From: Sarah Burrow <Sarah.Burrow@arun.gov.uk>
Sent: 18 March 2022 11:59
To: Planning.Responses <Planning.Responses@arun.gov.uk>
Cc: Obafemi Okusipe <Obafemi.Okusipe@arun.gov.uk>
Subject: RE: Planning Consultation on: LU/5/22/PL

Engineers Comments Regarding Surface Water Drainage

Application No: LU/5/22/PL
Registered: 15th February 2022
Site Address: 37 Griffin Crescent Littlehampton BN17 7LH
Grid Reference: 502912 103775
Description of Works: Change of use from a single dwelling into two flats and rear two storey extension and rear dormer. This application is in CIL Zone 2 (Zero Rated) as flats.

DRWG No: **1049_201**

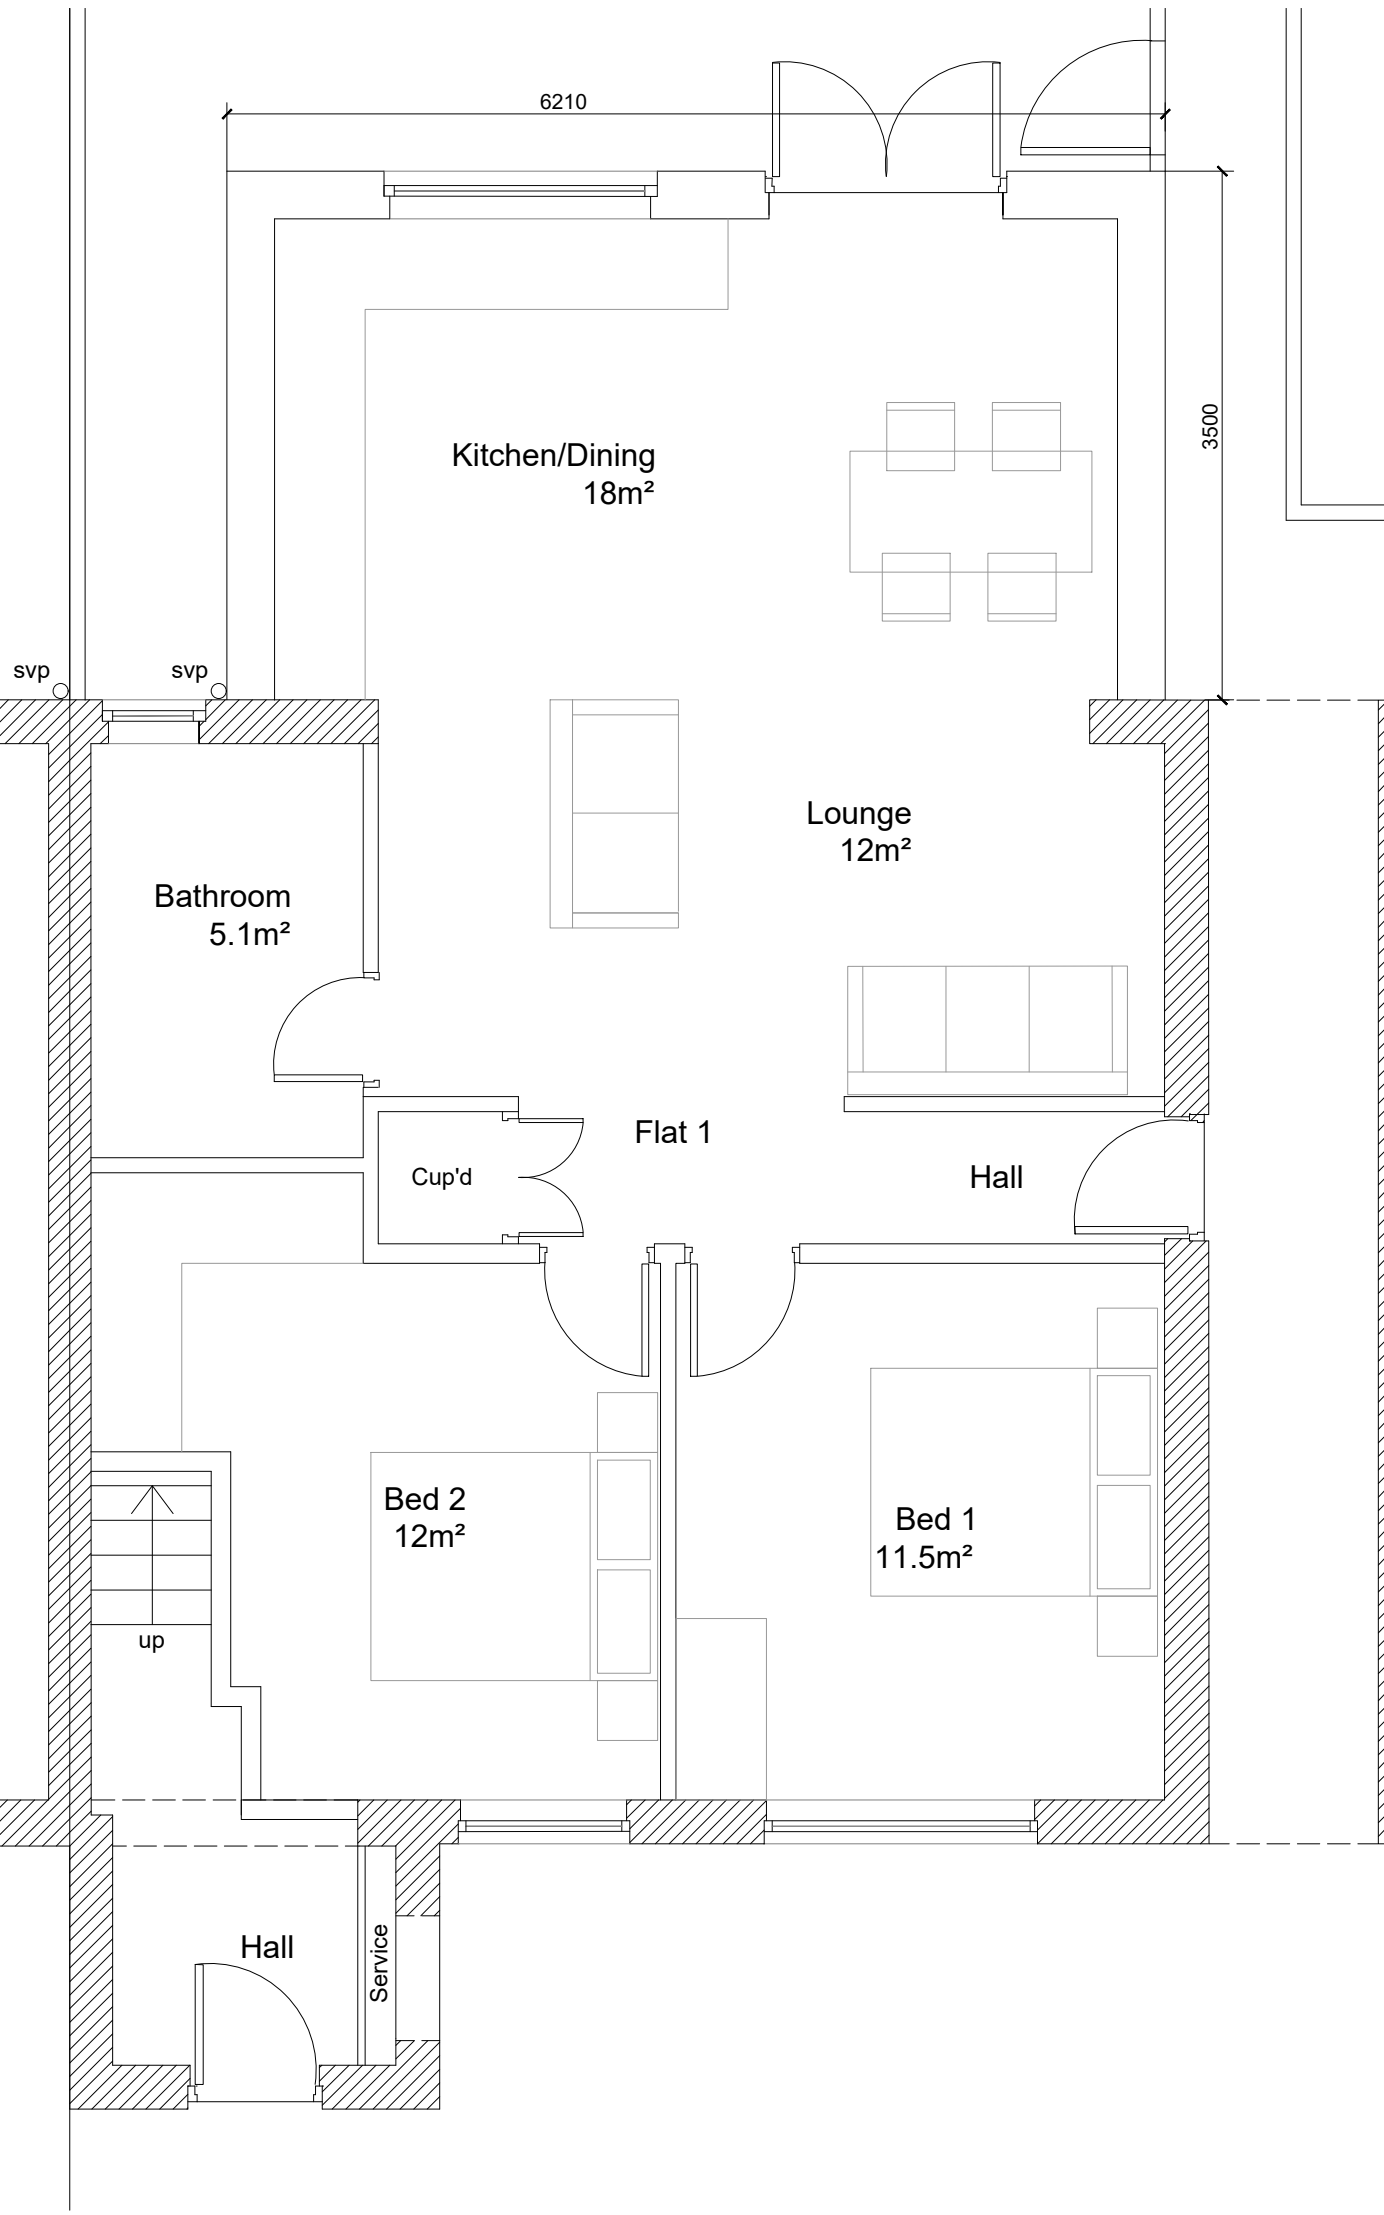
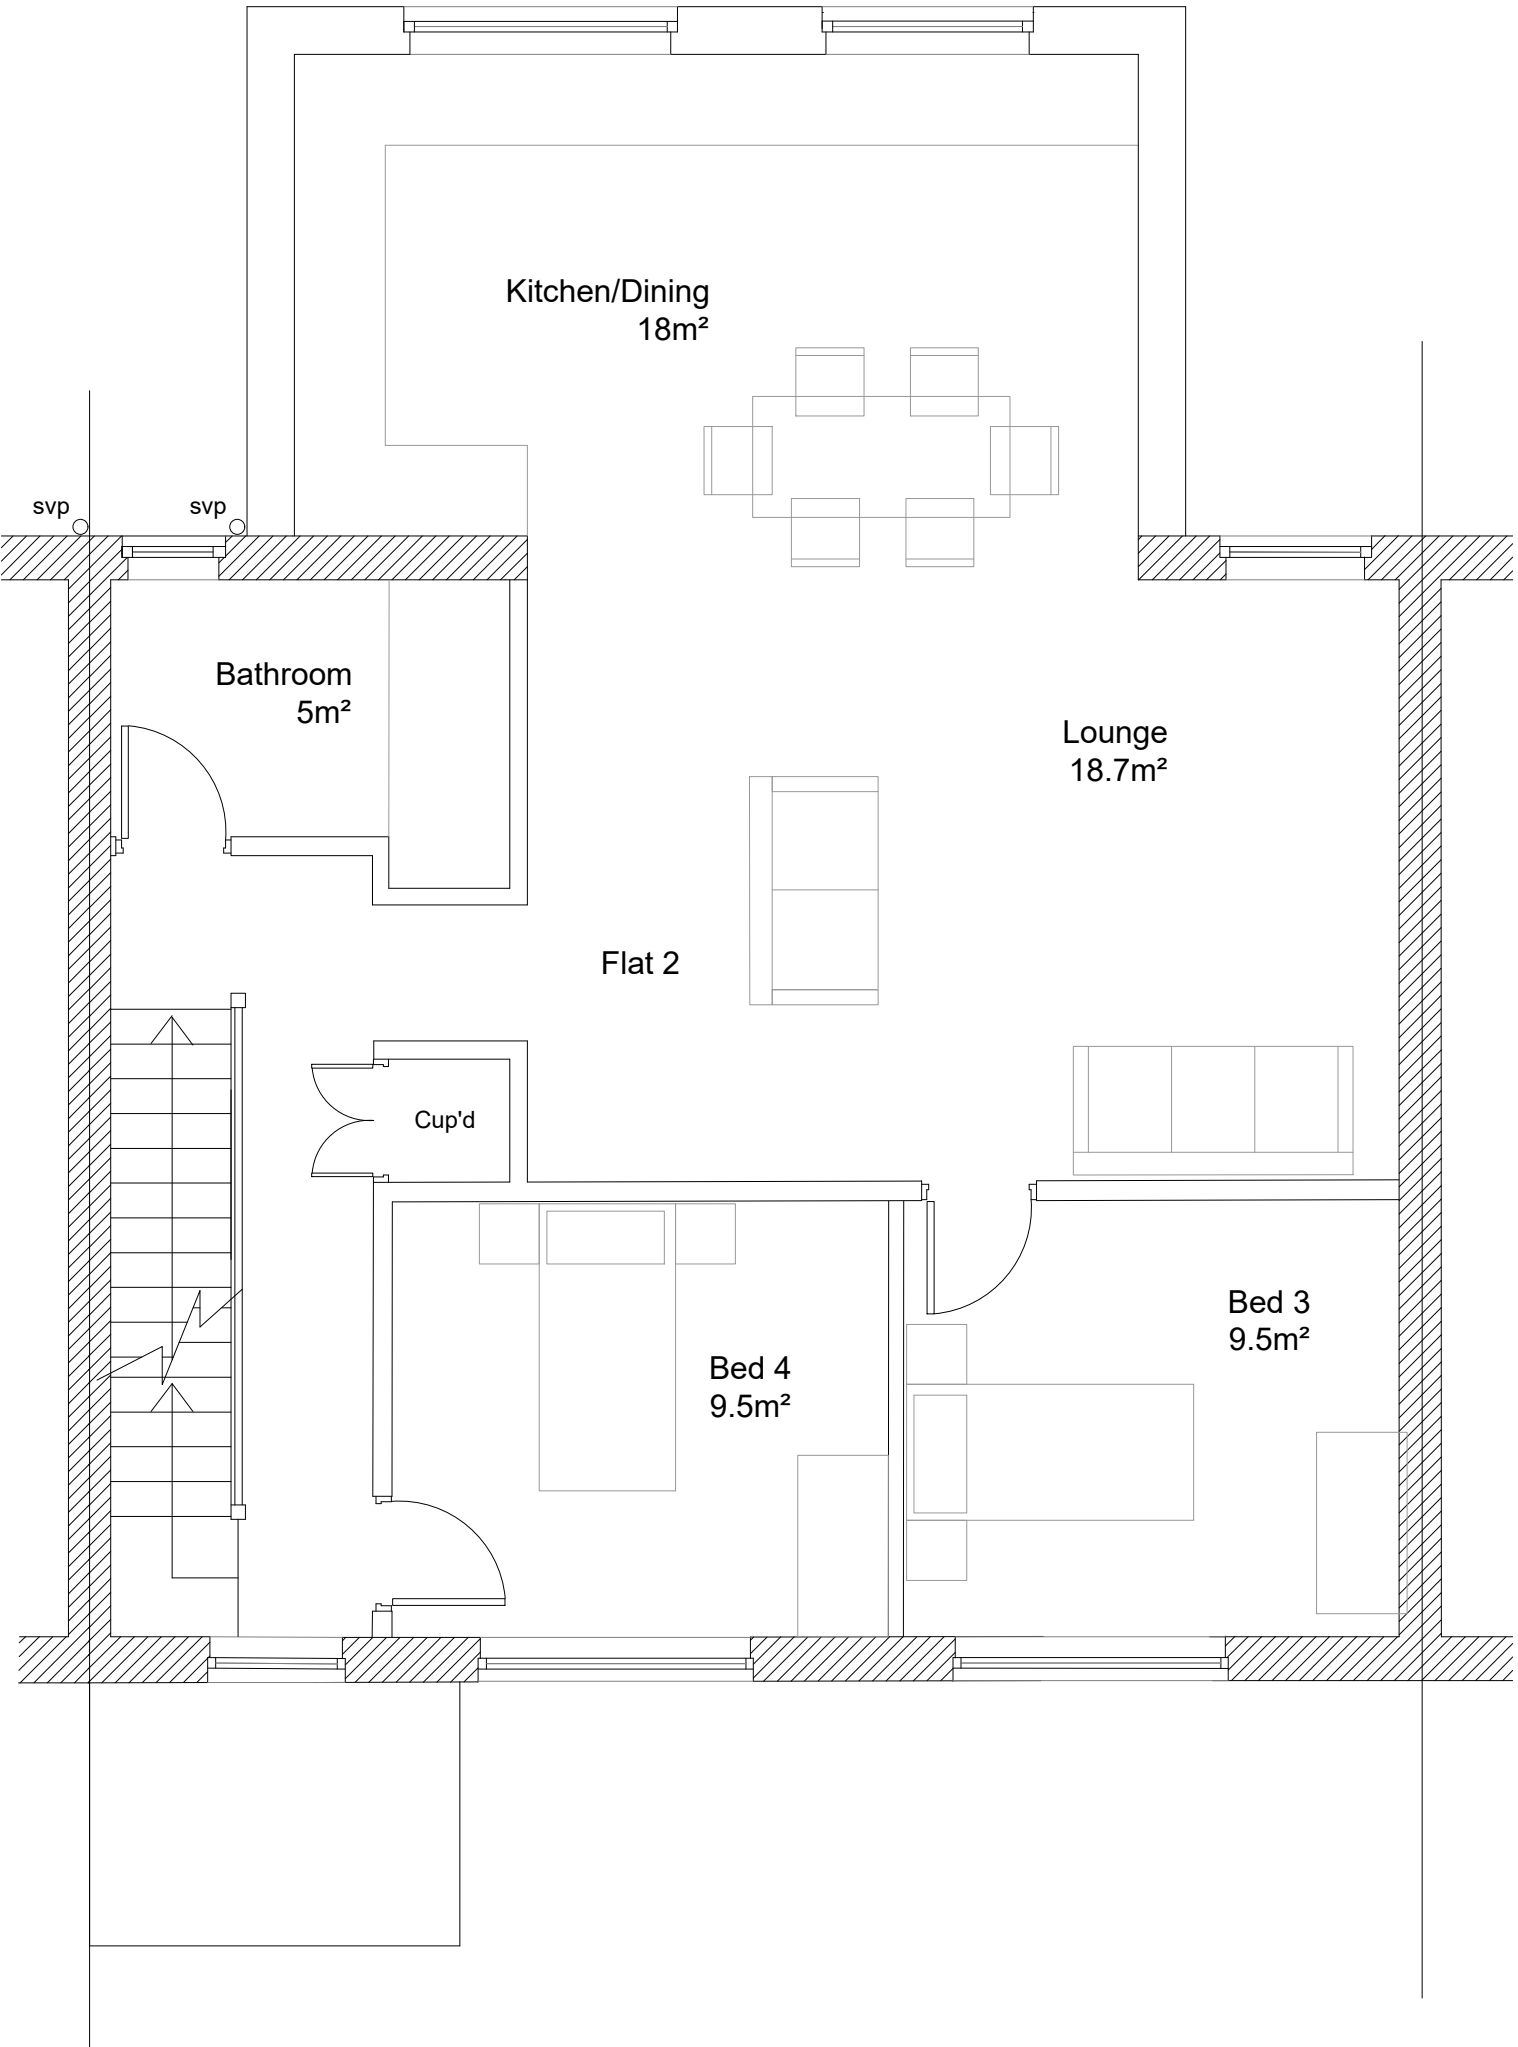
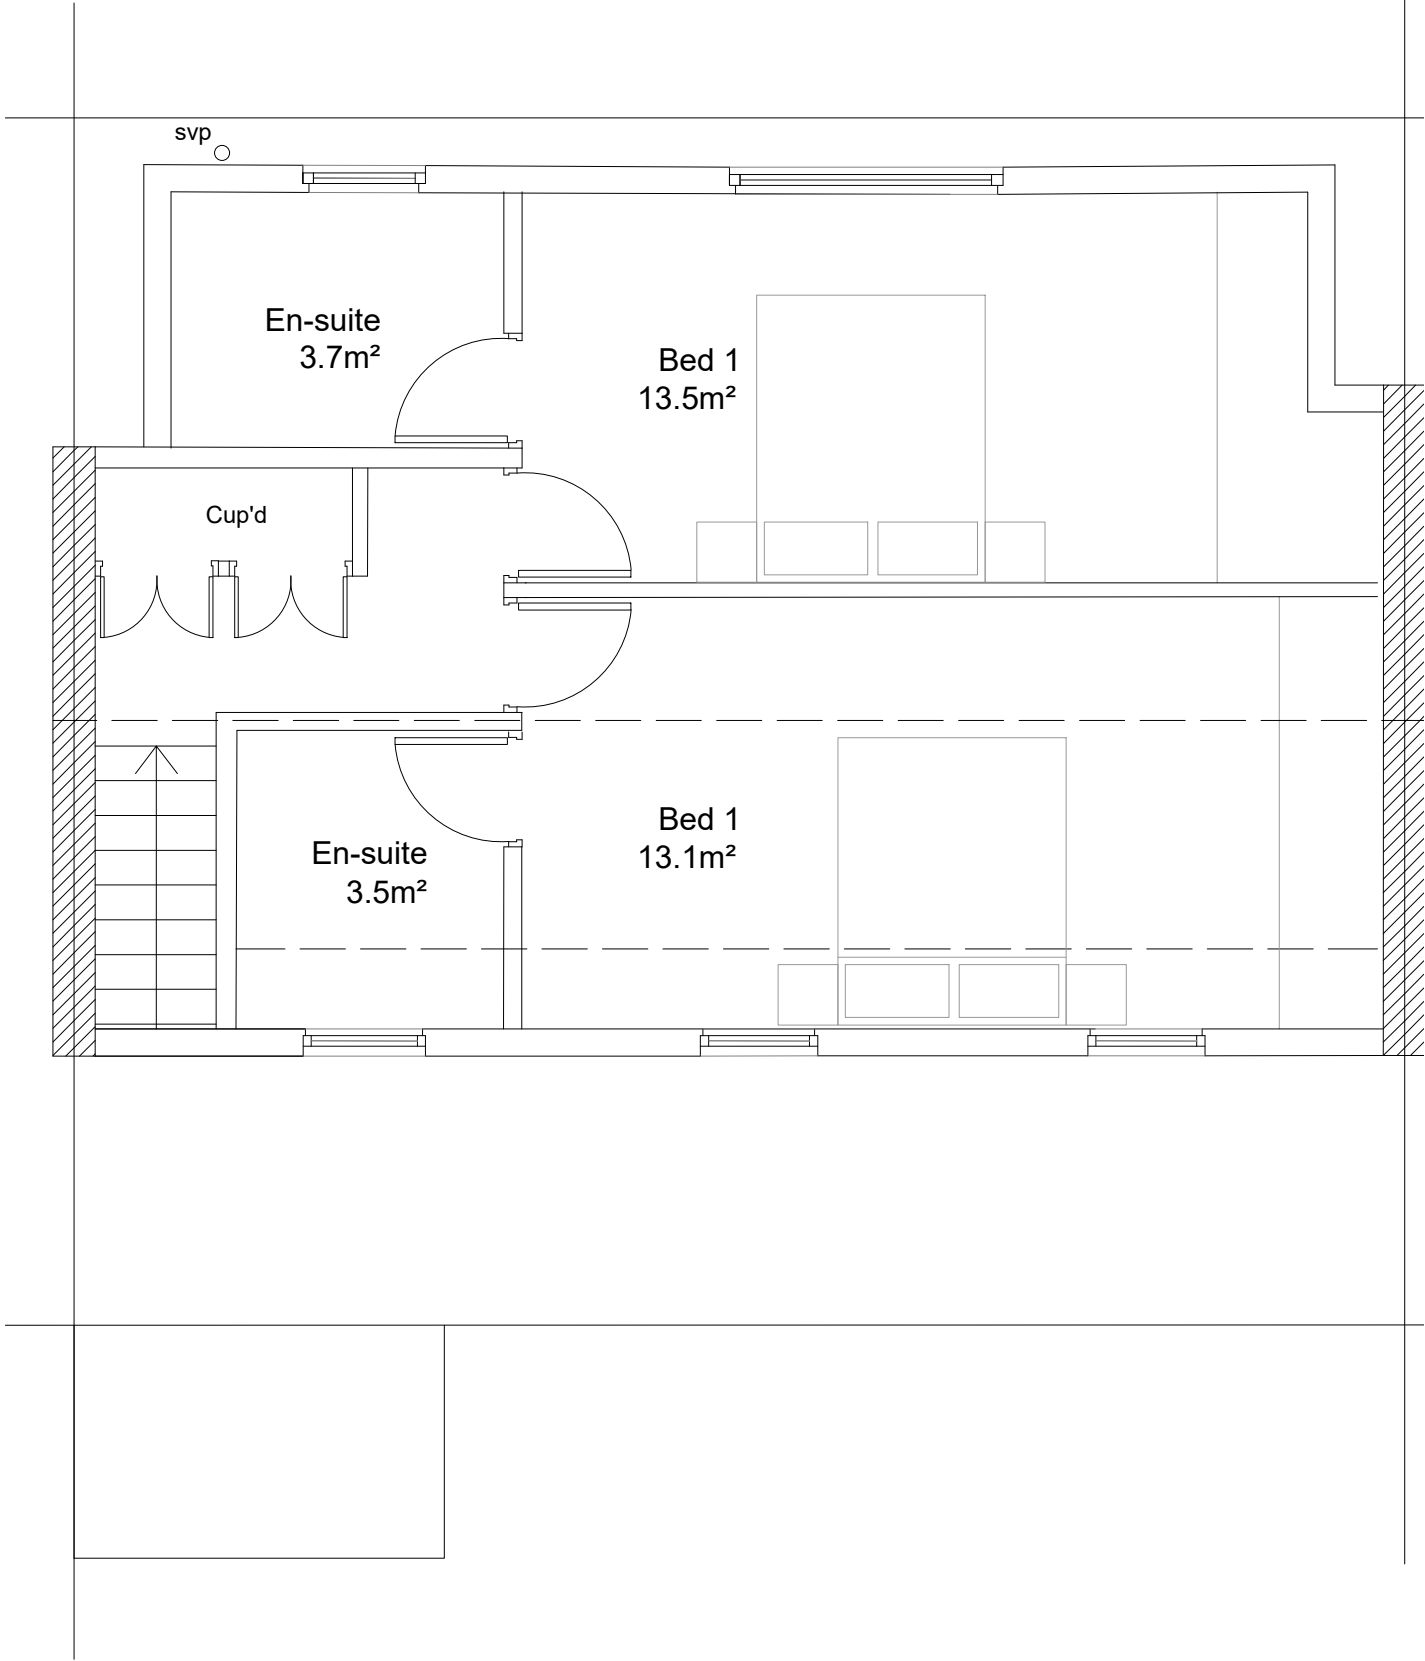
The applicant should be aware that our mapping shows a foul water sewer running through the rear garden in very close proximity to the proposed extension. Please consult Southern Water regarding this.
